## 23/01586/REM Himley Village Phase 2A

### Urban Design Comments

8<sup>th</sup> August 2024

# HIMLEY VILLAGE, BICESTER – STREET SCENES

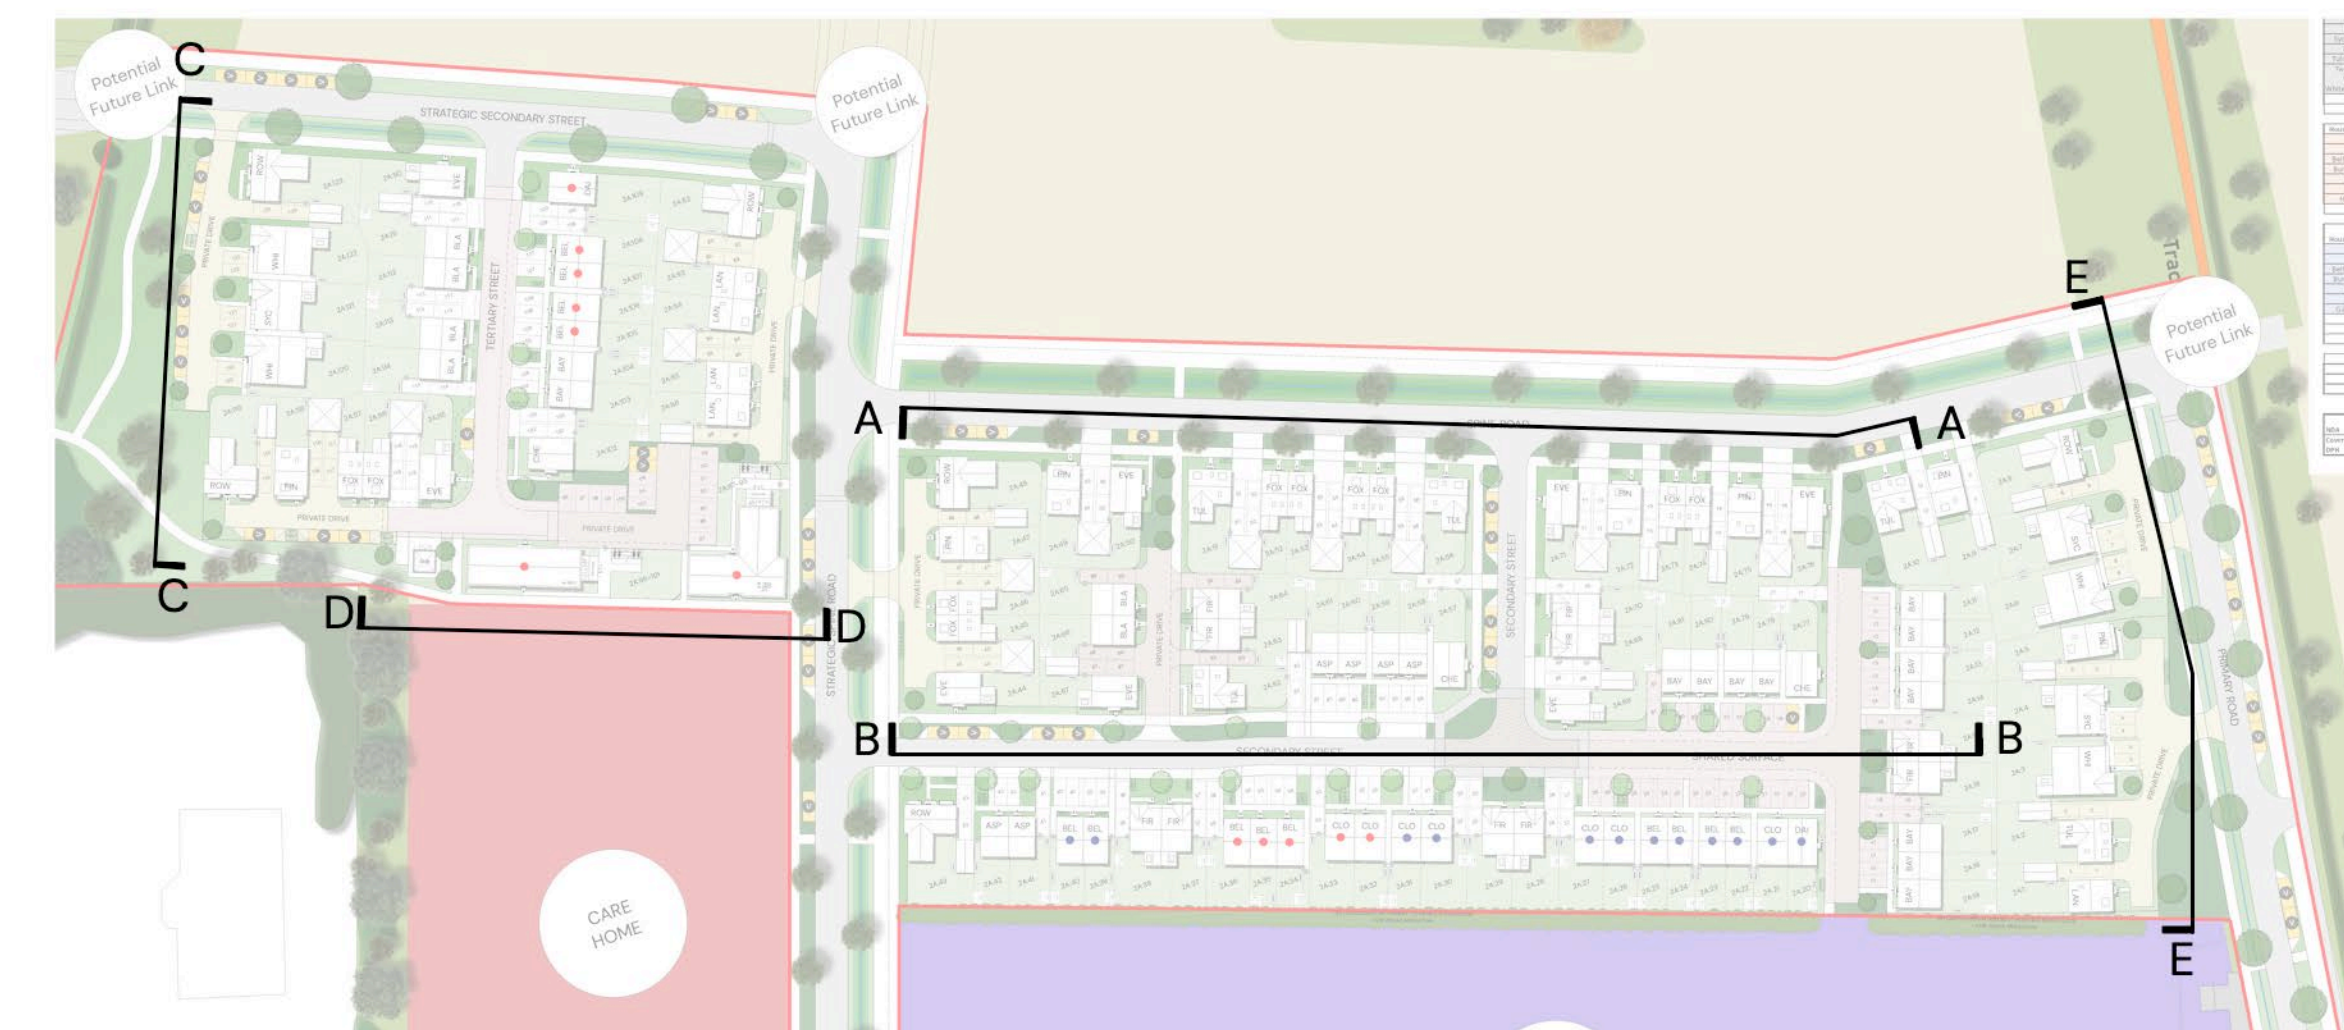
The proposed appearance is a generic reflection of Elmsbrook rather than the distinctive interpretation of local character and sustainable forms expected by policy and guidance. The design relies upon a large palette of brick colours, cladding and roof tiles to differentiate character within standard house types. Variations in roofscape and height appear to relate to specific house types rather than sustainability criteria and legibility. Ancillary building such as cycle and bin stores also need to be integrated into the street scene. The built form proposals do not reflect BfHL, which expect places with locally inspired or otherwise distinctive character. BfHL states that development should not attempt to create character through poor replication of architectural features and details; or arrange buildings next to each in a manner that does not create a cohesive street scene.

TITLE
DRAINAGE STRATEGY - PHASE 2A

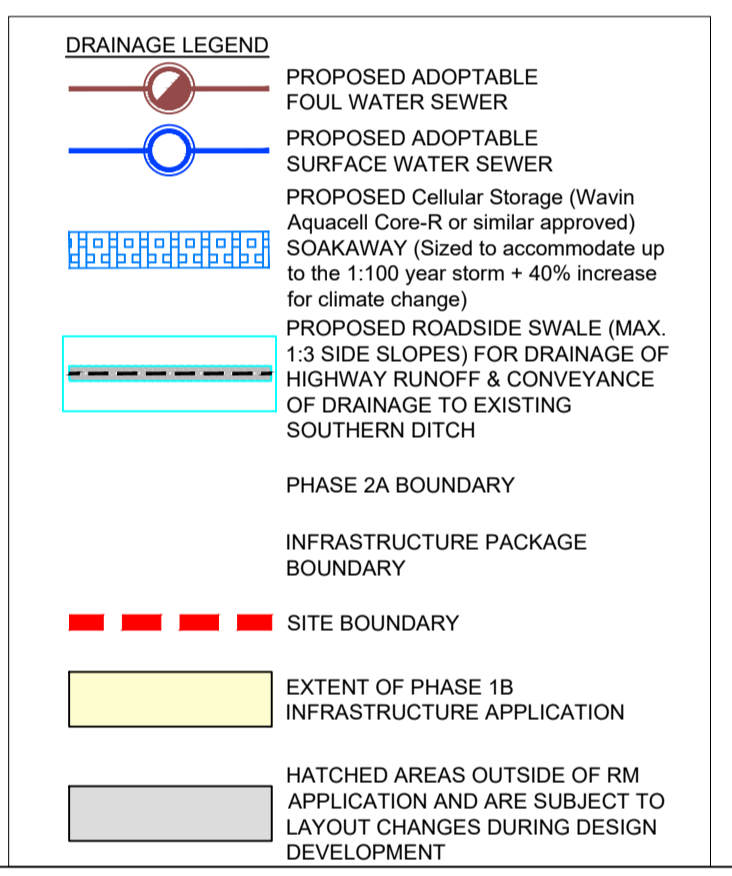
The public realm proposals do not integrate planting and SuDS features. Features such as channels and secondary swales or rain gardens are key elements of the drainage strategy illustrated in the outline DAS and drainage parameter plan. The planting and drainage scheme does not reflect the standards of good design as set out in BfHL, which states that creative surface water features enrich the public realm and help improve a sense of wellbeing and offer interaction with nature.
